Ref: TR010056

**Submission made by National Highways pursuant to Deadline 4 of the Examination of the A417 Missing Link scheme**

# **Appendix A: Overview of changes made to General Arrangement Plans, Land Plans, Works Plans, Rights of Way and Access Plans, Environmental Masterplans and Traffic Regulation Measures Plans**

**FIGURE 7.9  
RETAINED VEGETATION  
SHEET 1 OF 6**

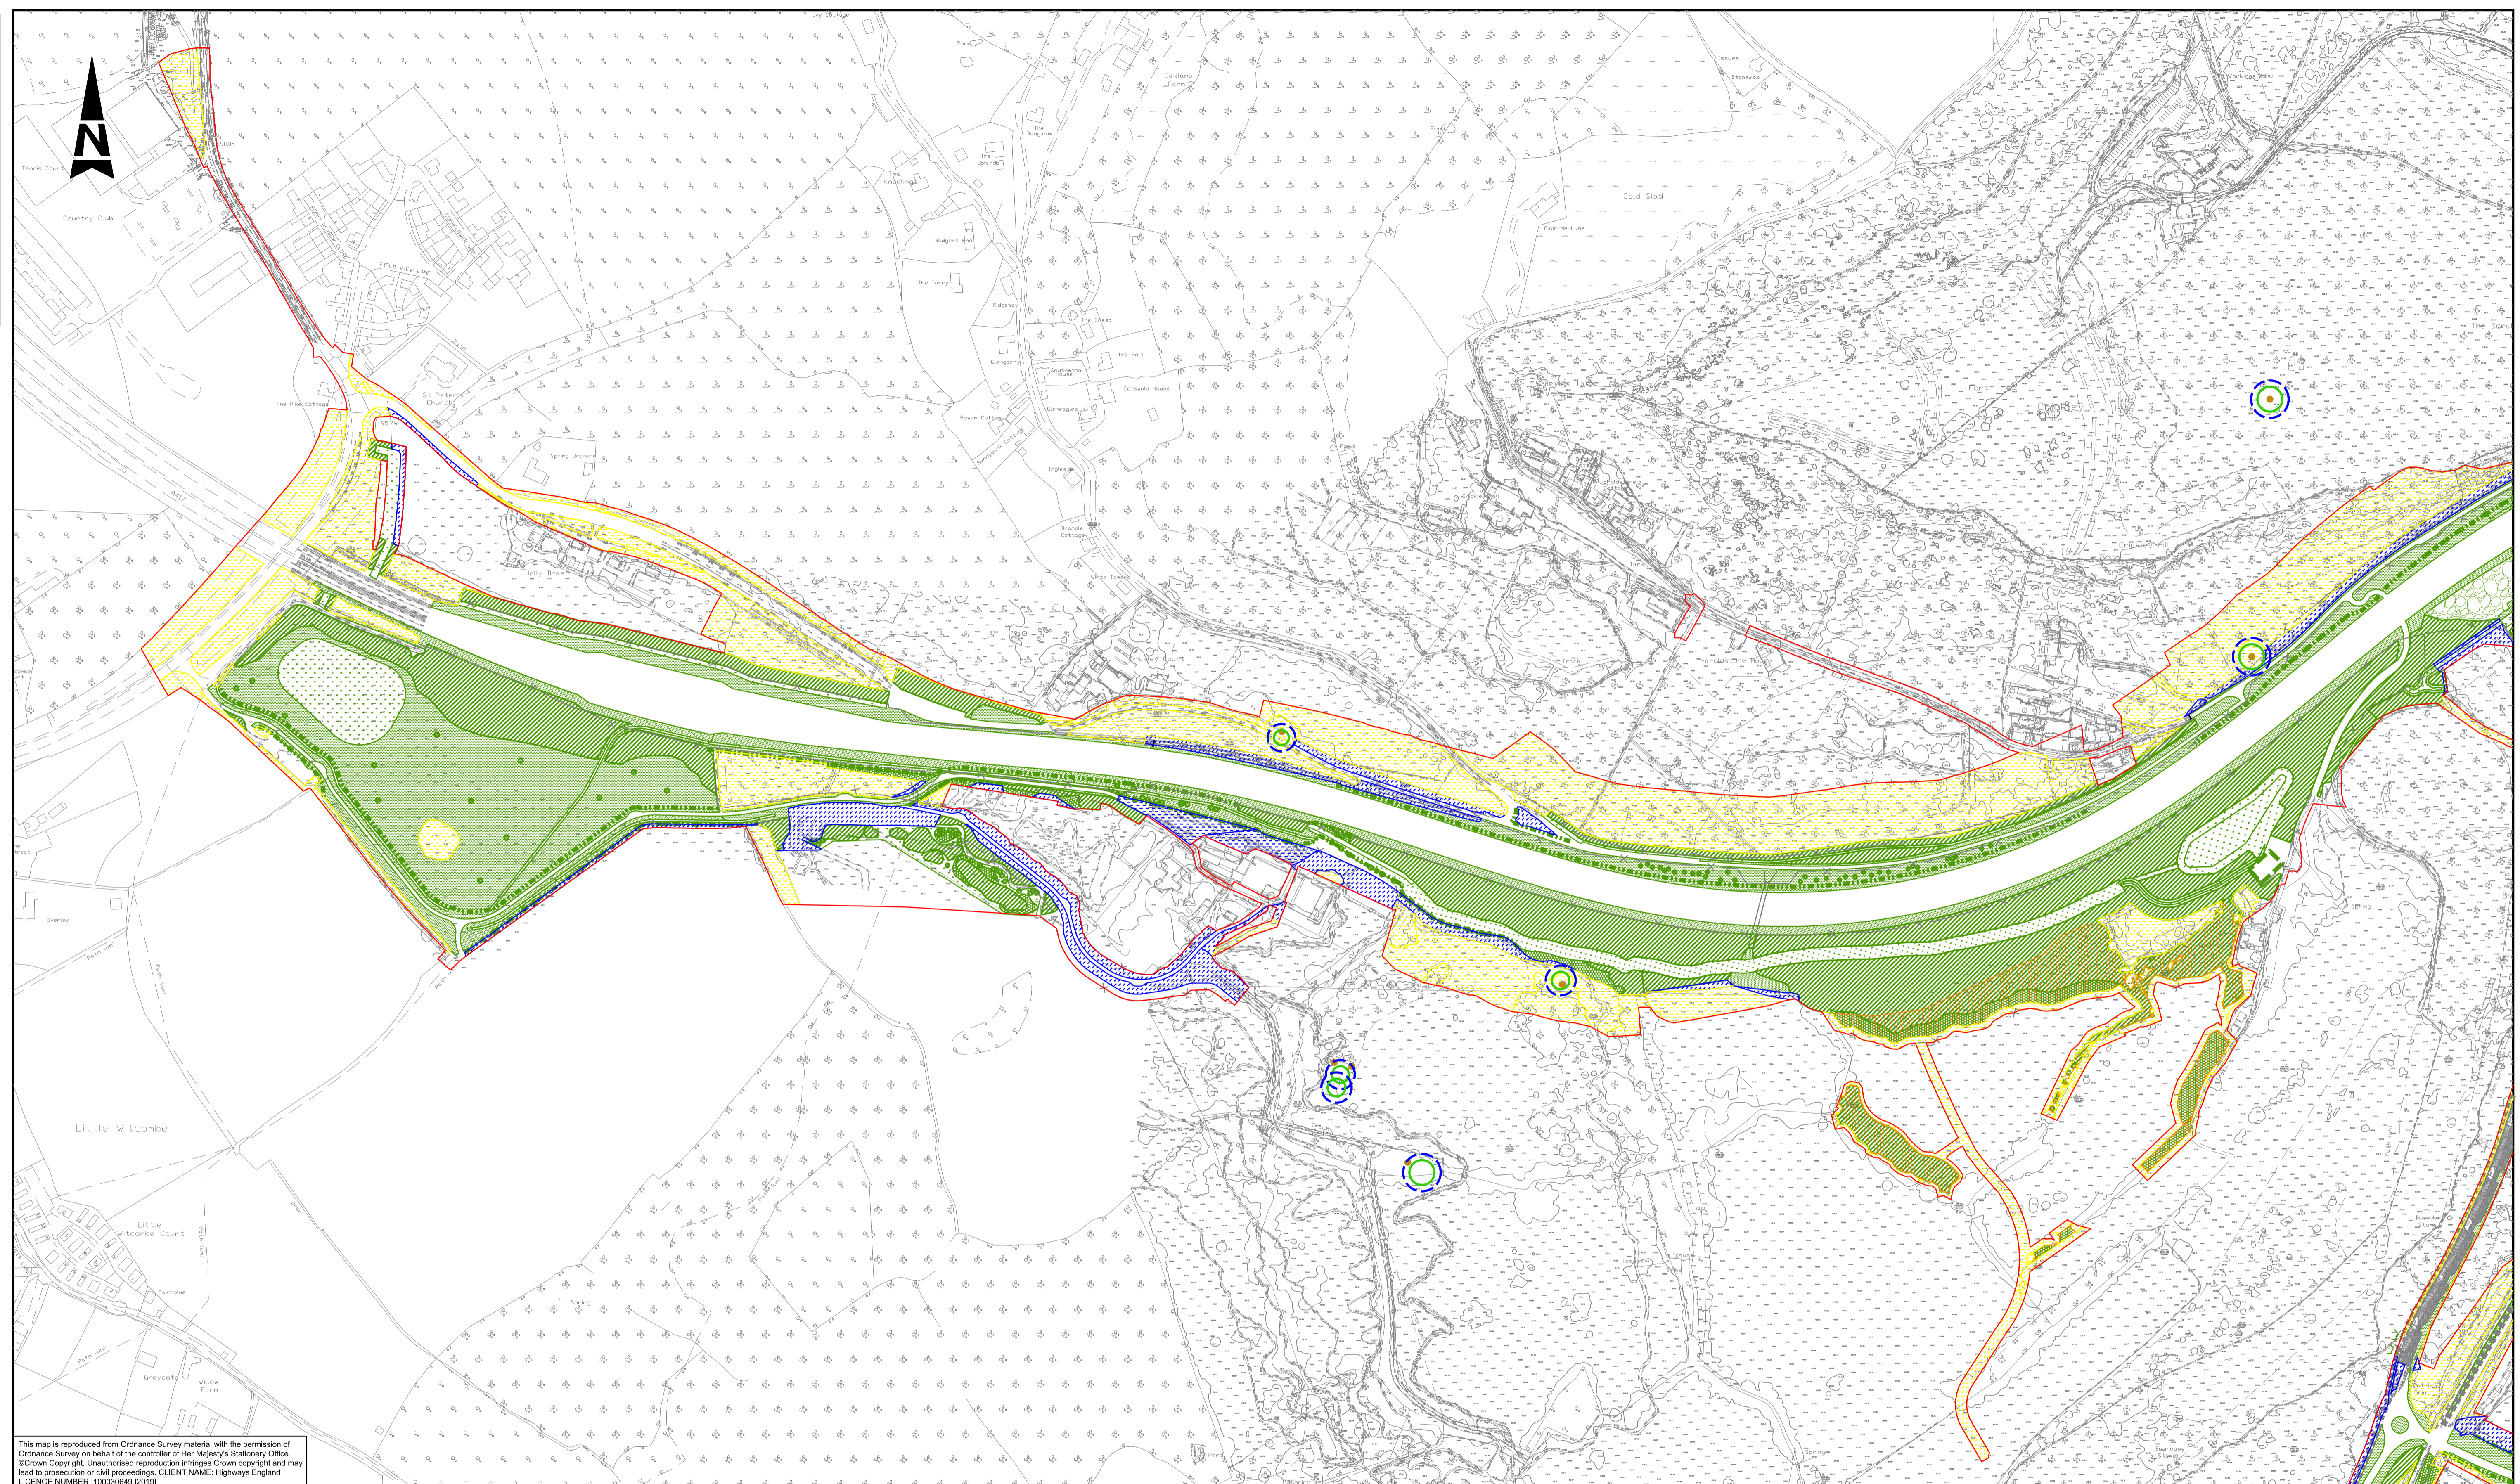
Sheet 1	Minor amendments to reflect Flyup 417 Bike Park design change.
<b>ES Figure 7.9 Retained Vegetation (Document Reference 6.3 (Rev 1))</b>	
Sheet 1	Minor amendments to reflect Flyup 417 Bike Park design change.
<b>ES Figure 7.11 Environmental Masterplans (Document Reference 6.3 (Rev 1))</b>

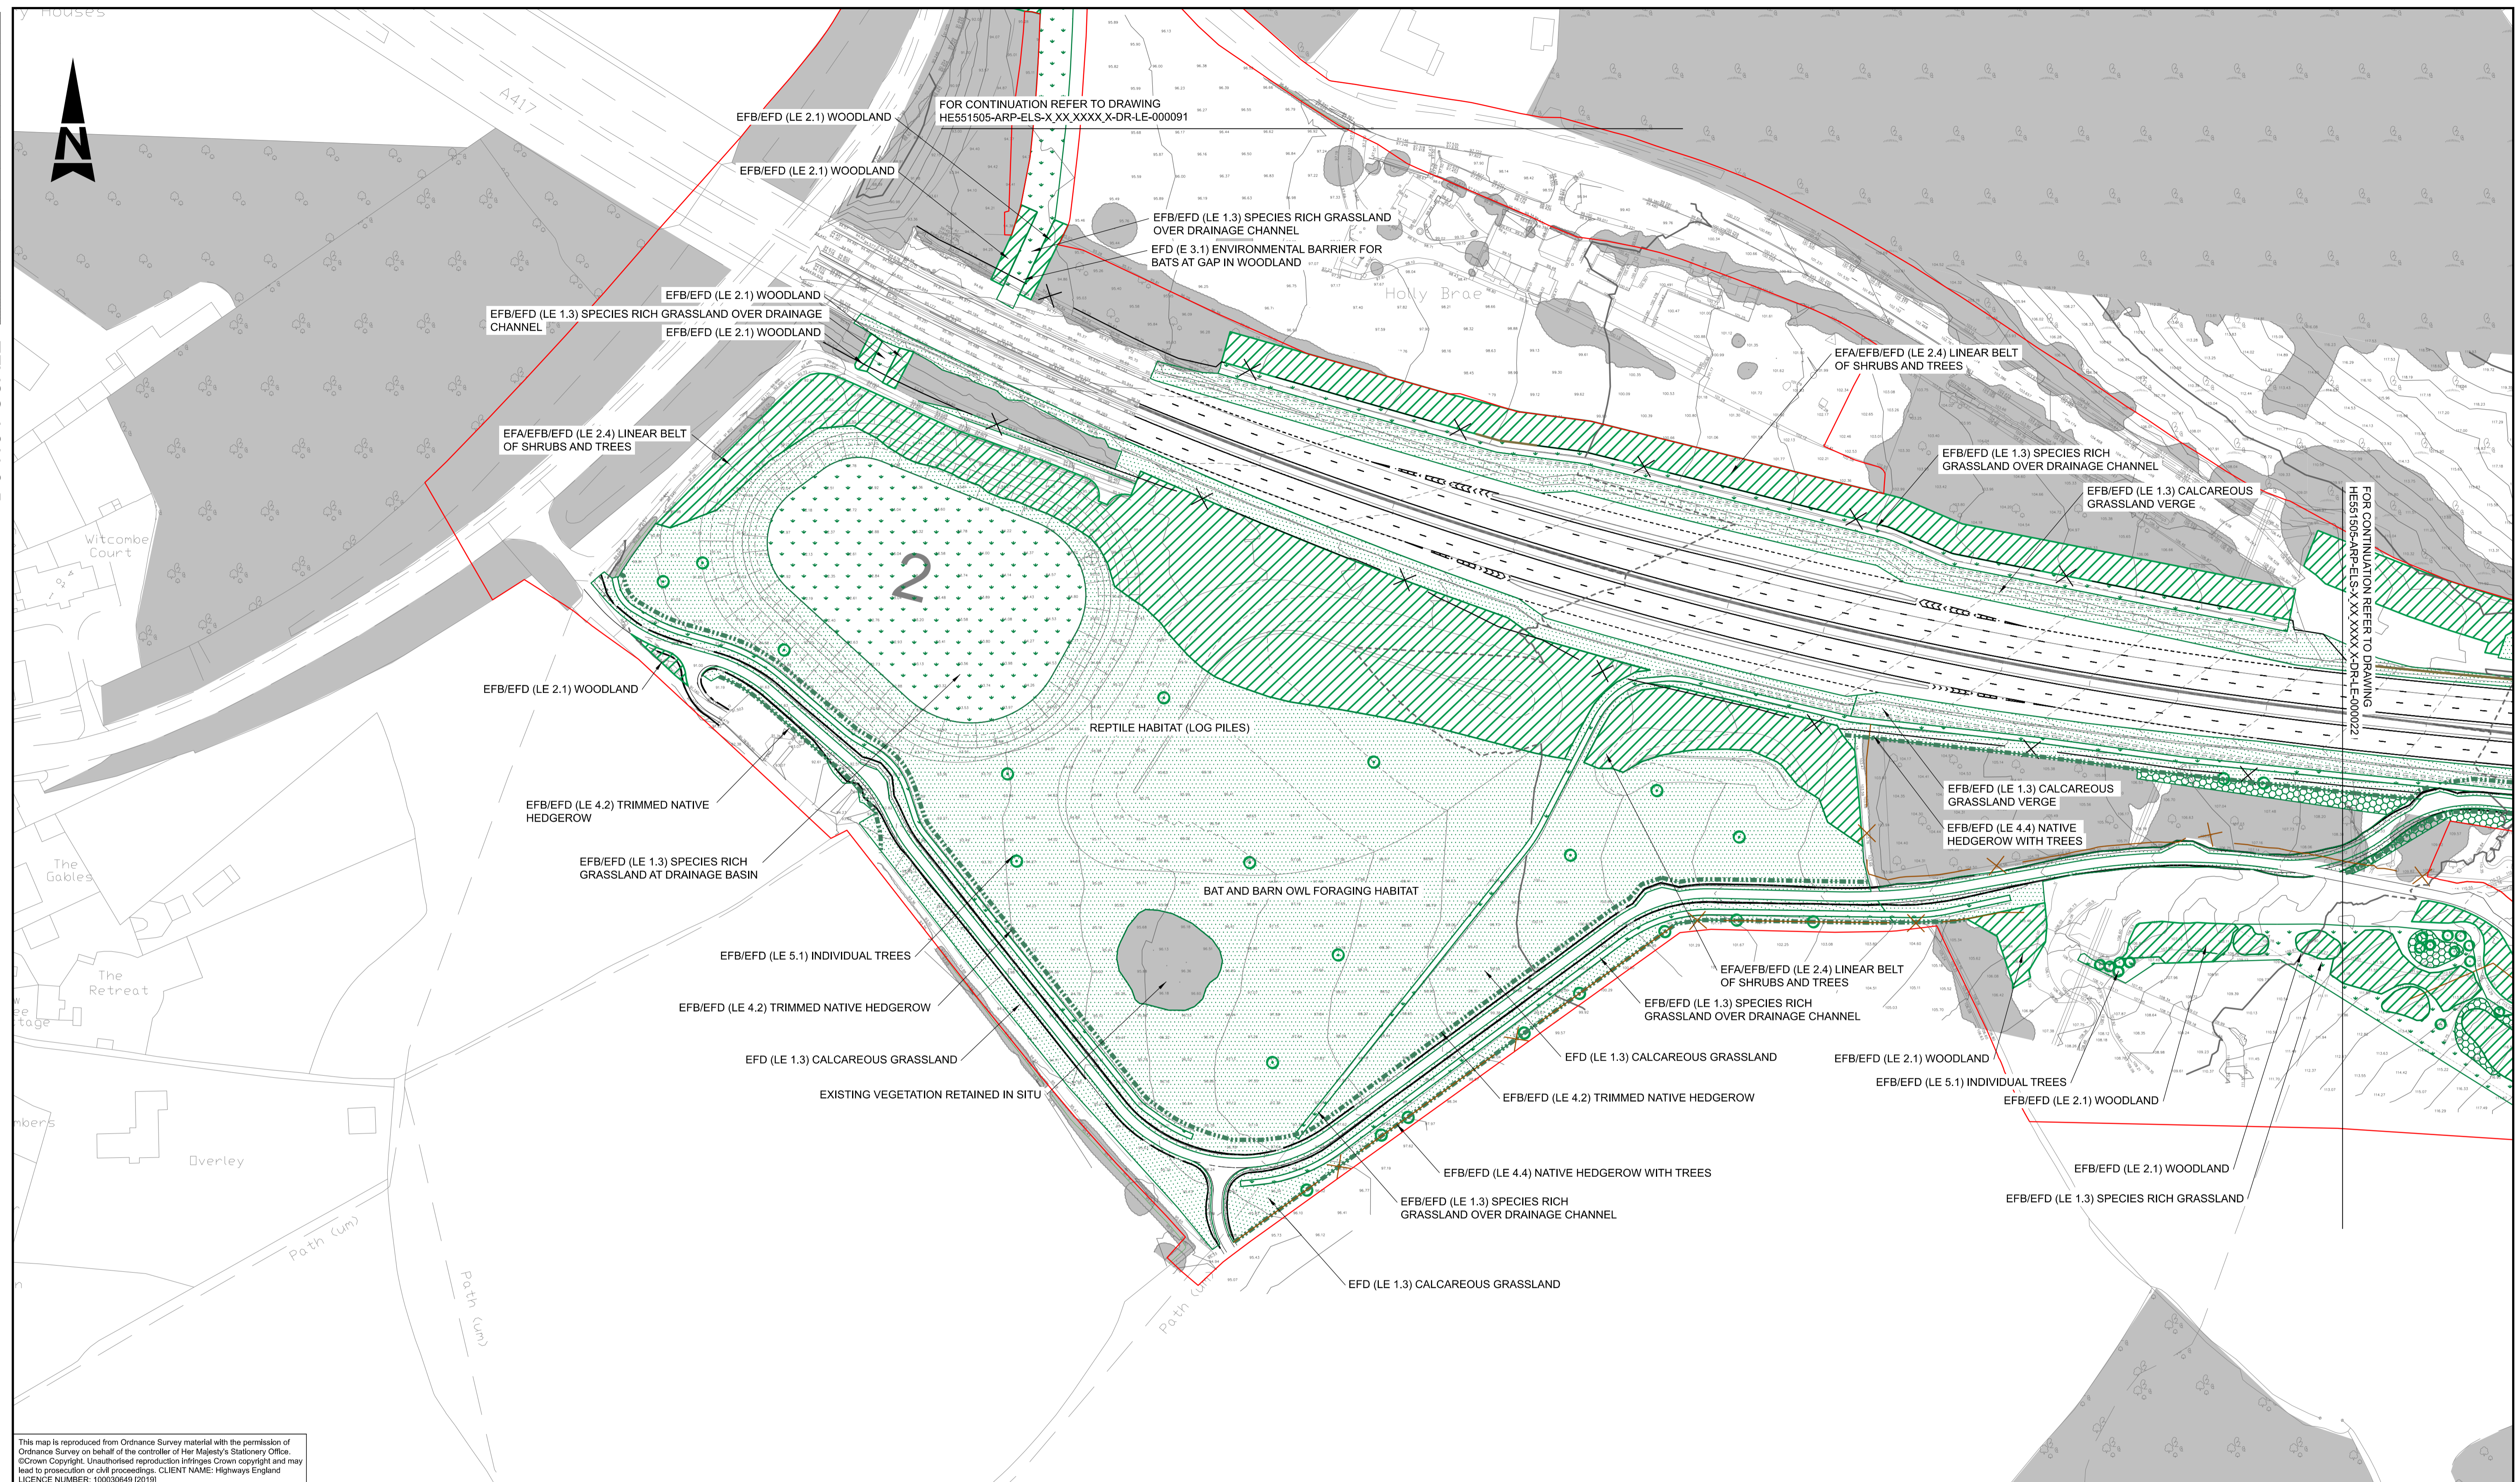
Sheet 2 of 25	Changes due to Flyup 417 Bike Park design change: <ul style="list-style-type: none"> <li>• Amendments to essential mitigation planting</li> </ul>

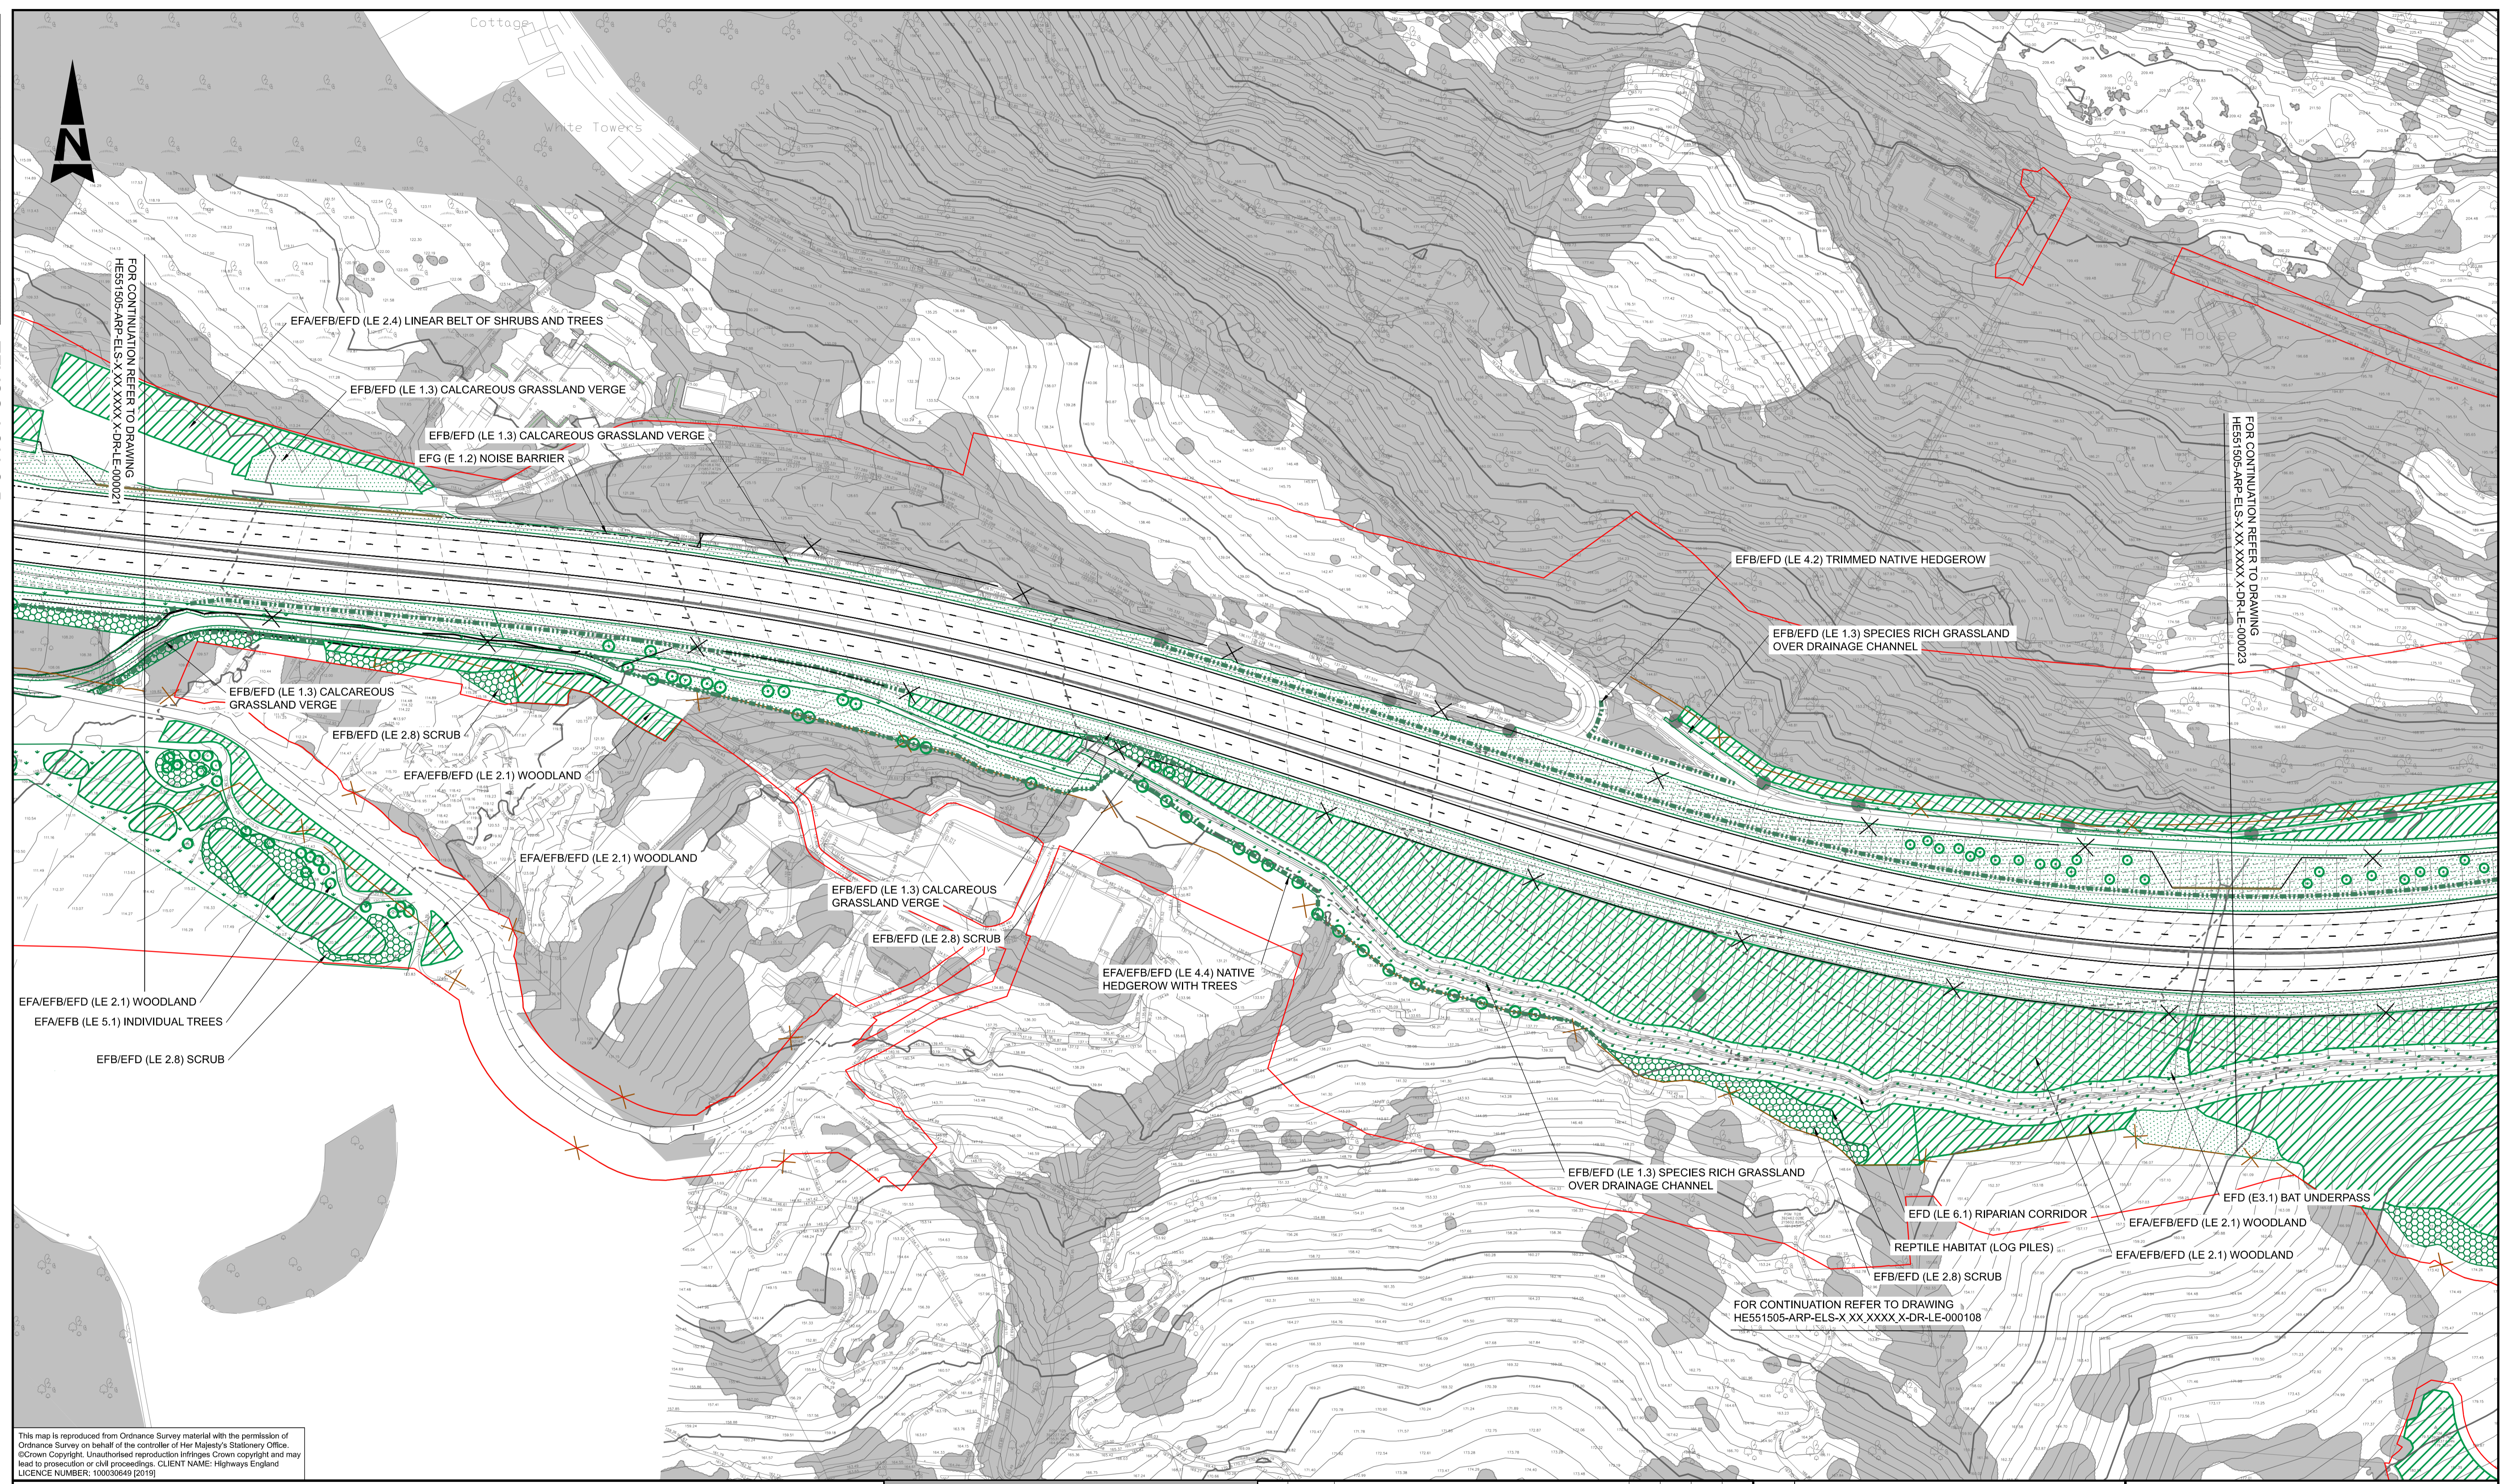
Sheet 3 of 25	Changes due to Flyup 417 Bike Park design change: <ul style="list-style-type: none"> <li>• Amendments to essential mitigation planting</li> </ul>
